Application number: 2023/90444	
What is the application for?:	Erection of detached dwelling
Address of the site or building:	Land adj, Fern Bank, Far End Lane, Honley, Holmfirth, HD9 6NS
Postcode:	HD9 6RP

Type of comment: An objection	
Do you wish your comments to be published on the website anonymously?	Yes

Proposed Ground Floor Plan - 1:100

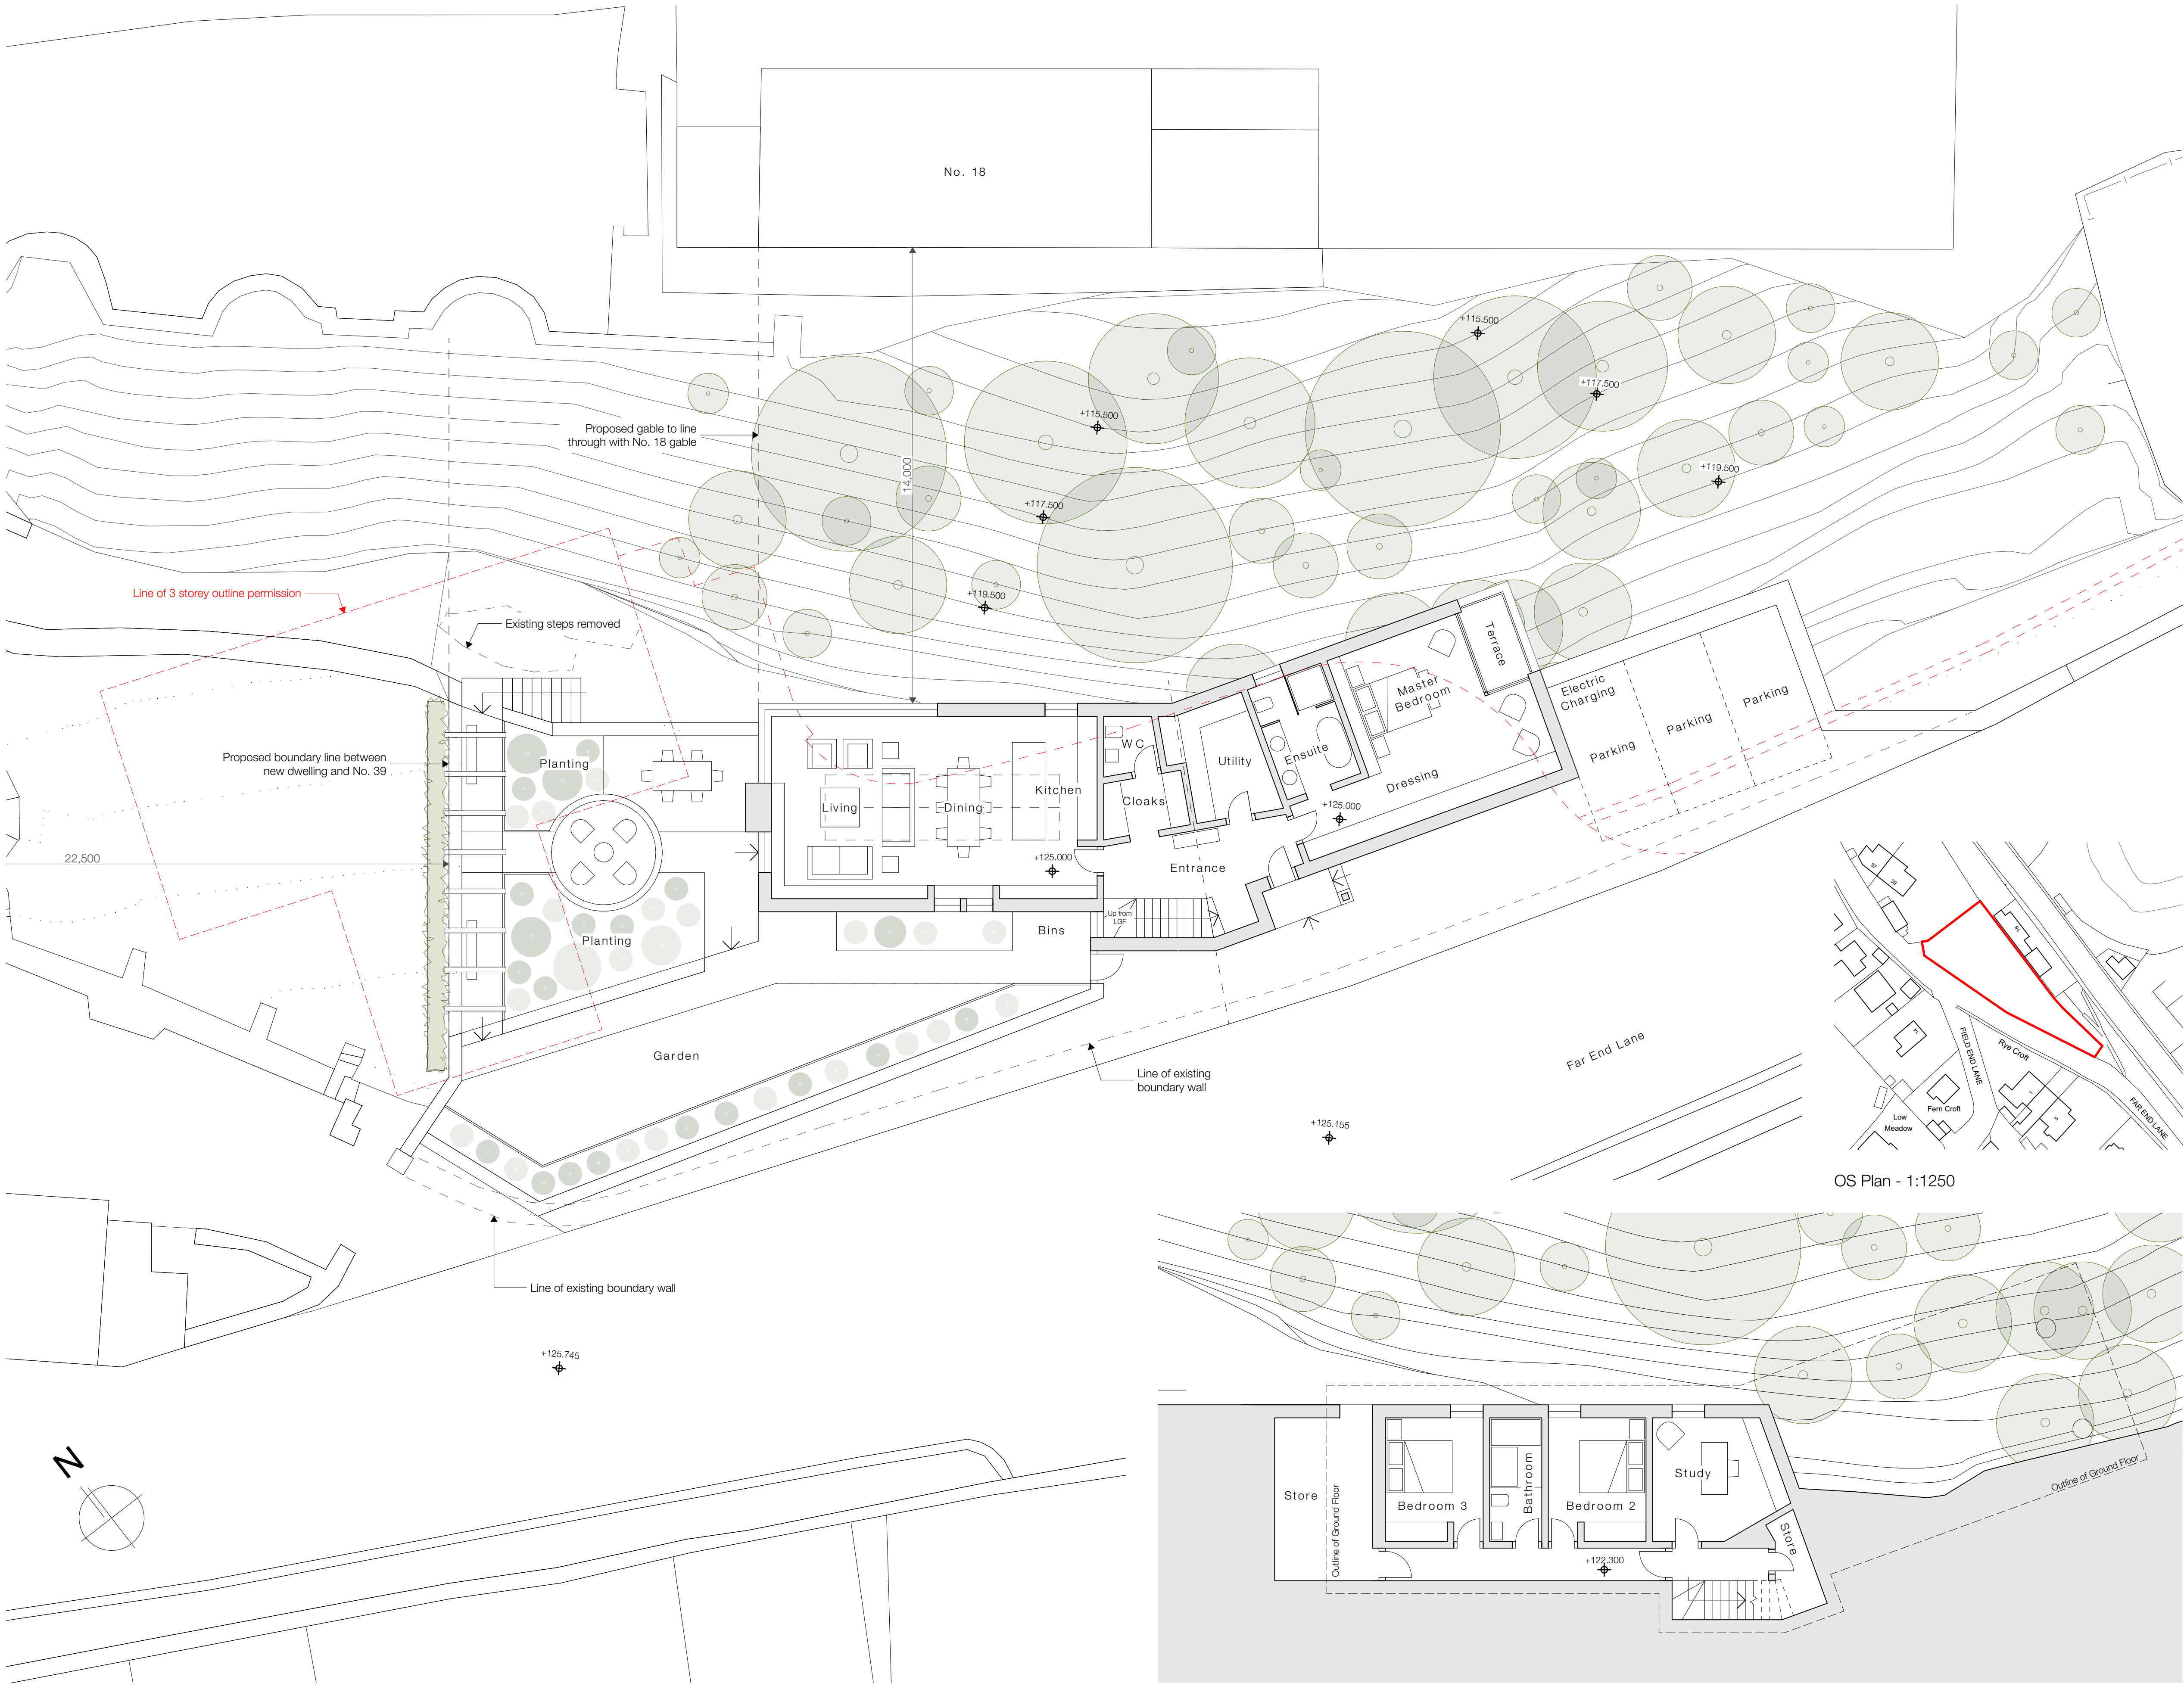
- Do not show any vehicular sightlines.
- Do not show any vehicle paths which demonstrate how vehicles return to the highway in a forward gear – the parked vehicle nearest the exit for example will need to make forward and reverse manoeuvres to use the exit and a U-turn to travel to the village centre.
- Appear to show alterations to the existing 2m boundary wall but this is not clear, and no details are given.
- Show two parking bays (with EV charging) positioned so they obstruct the view of oncoming traffic.
